CITY OF ALBUQUERQUE

May 2, 2008

**Re: Isleta Church of Christ Addition, 2424 Miles Road SE (M16-D40),
Traffic Circulation Layout
Engineer's Stamp Dated 4-18-08 (M16-D40)**

CHURCH ADDITION
ISLETA CHURCH
2424 MILES ROAD
ALBUQUERQUE, NEW MEXICO

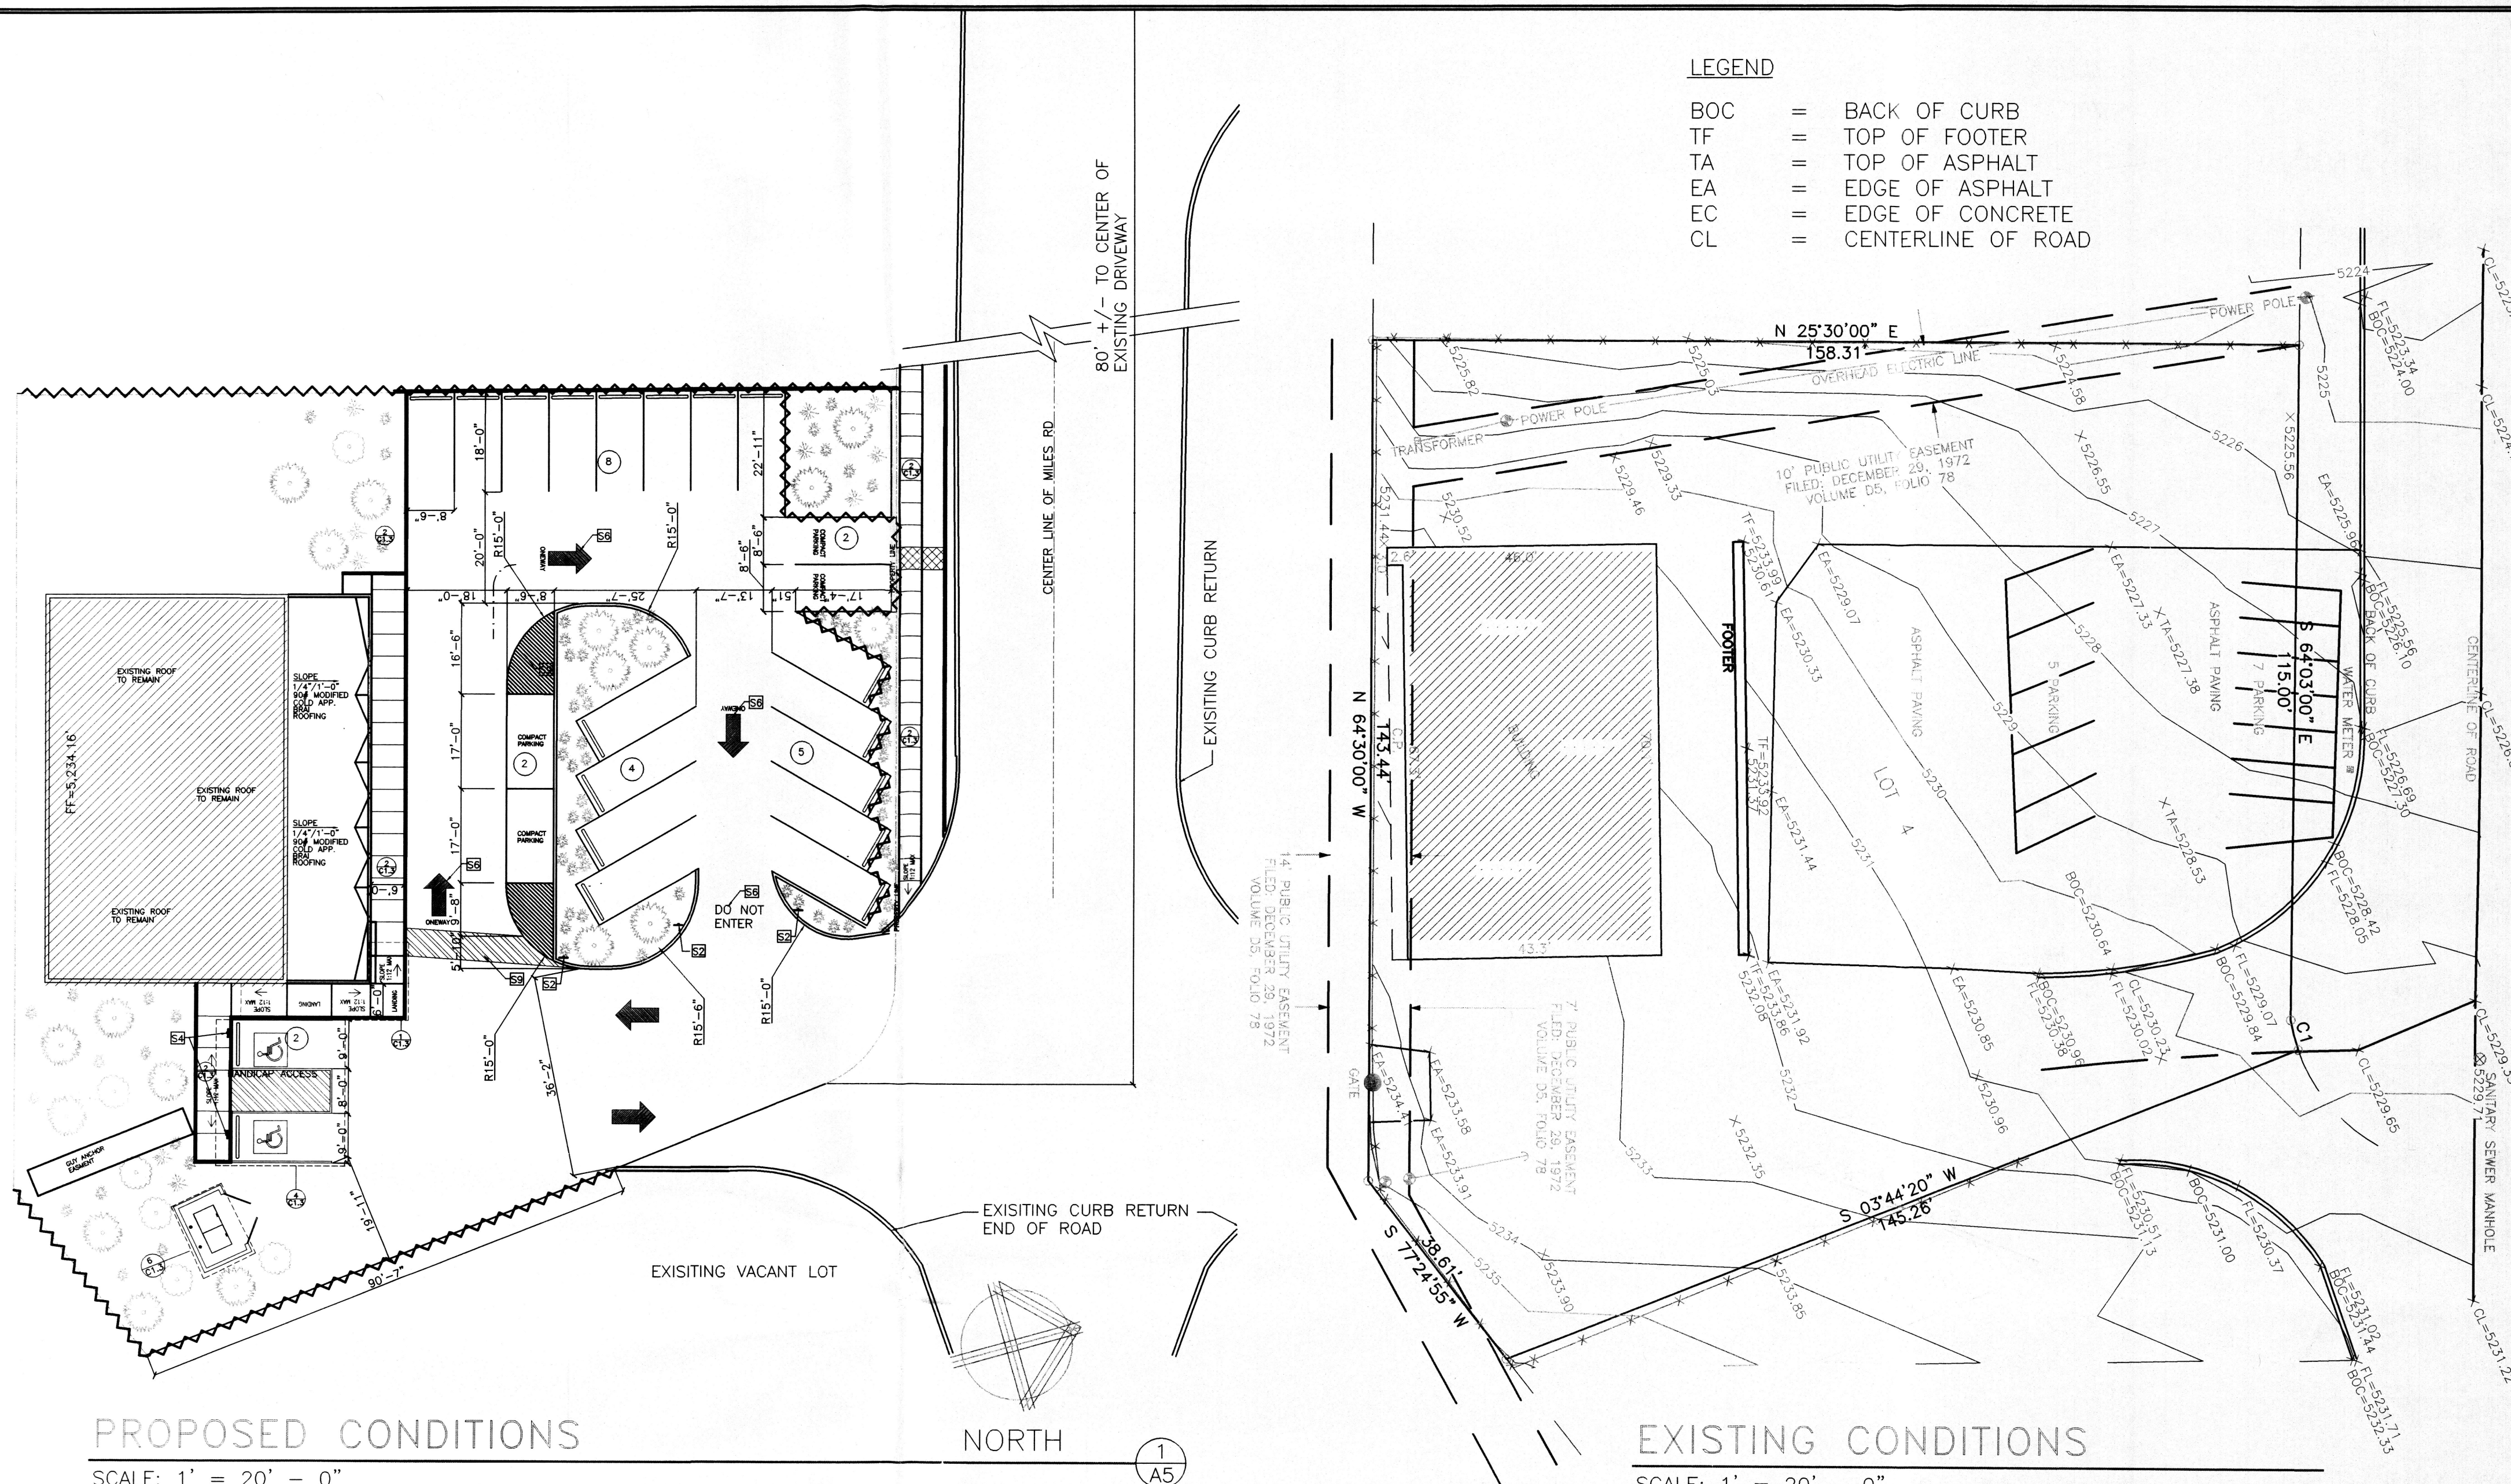
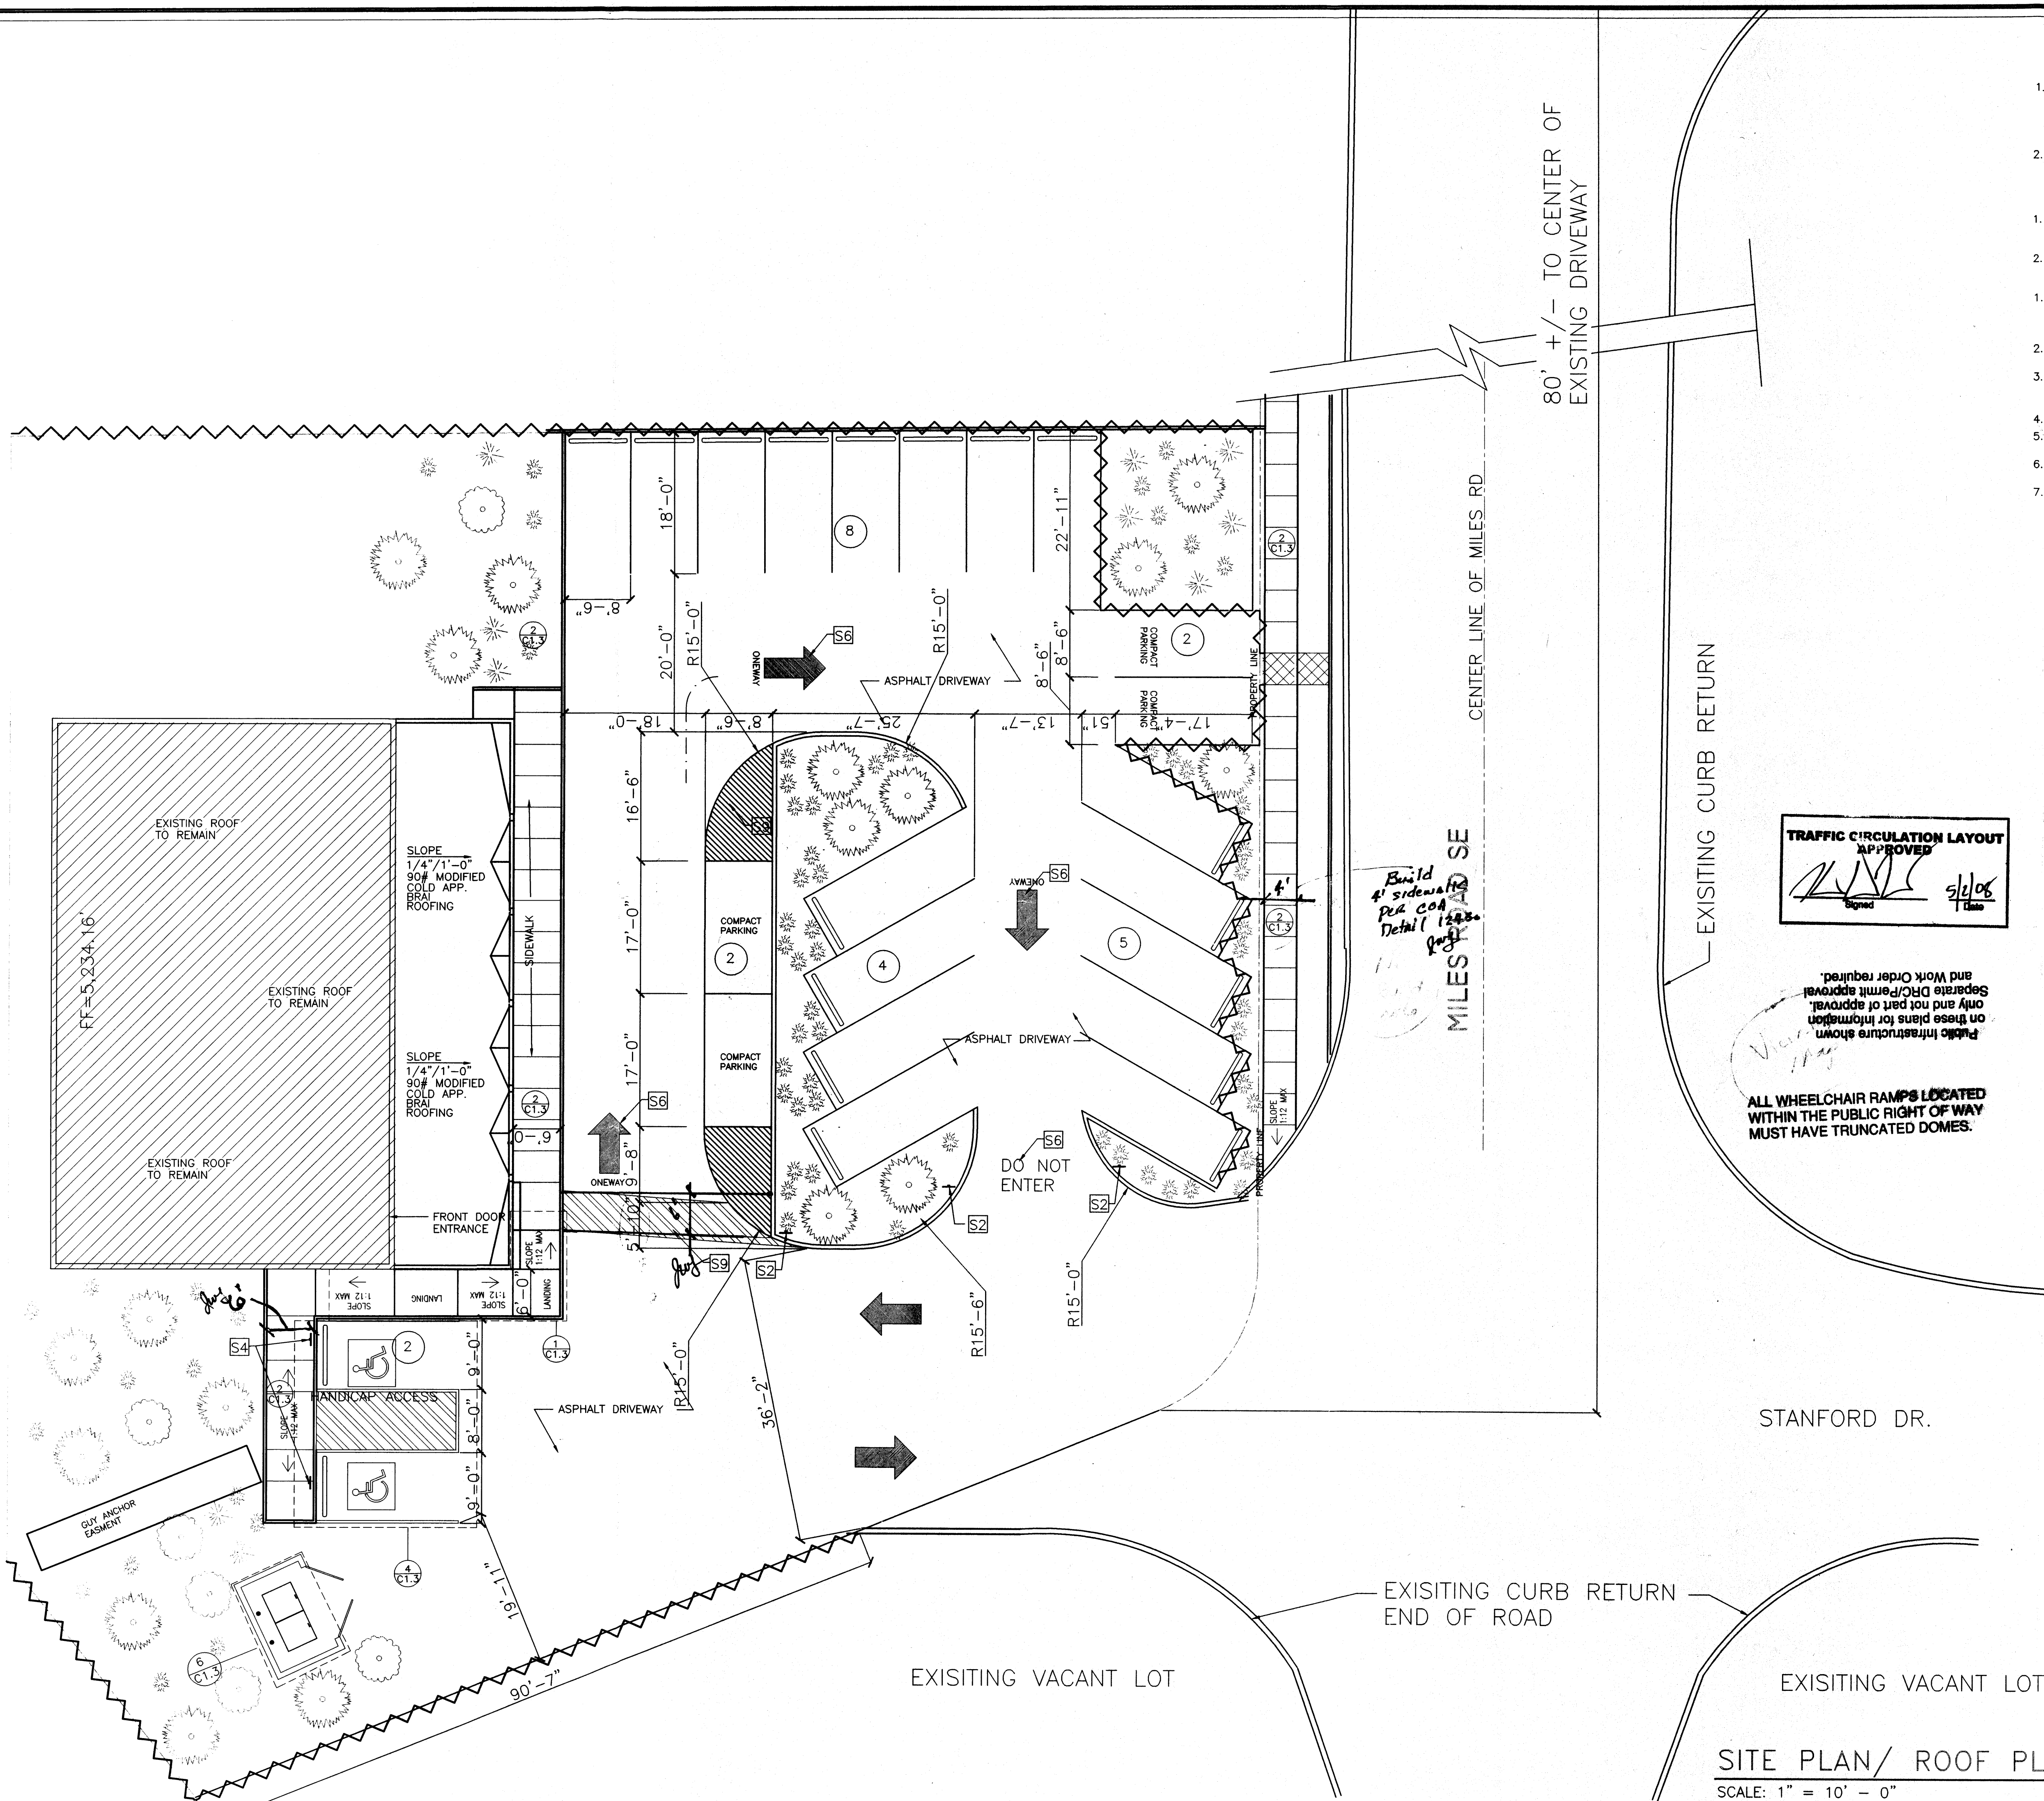
- The spot elevations shown on this plan will create ponding in the parking lot since some of them are almost 3 feet below Miles Rd.
- The plan does not provide adequate water blocks at the entrances to ensure that runoff in Miles stays in the road.

- On the western edge of the parking lot, it appears that 5 feet of fill will be needed. Is a retaining wall planned? This should be shown on plan and concurrence from the electric company will be required since there will be much less clear distance to the electric lines shown on your plan.

- The plan shows existing curb that must be removed (no note to that effect) and, more importantly, new curb that must be built in Miles. As you are aware, this curb must be built by City Work Order. It is not apparent what the extents of this curb would need to be to keep runoff from the north and east from entering your site.

- Please quantify any offsite runoff entering your site from the south and east.
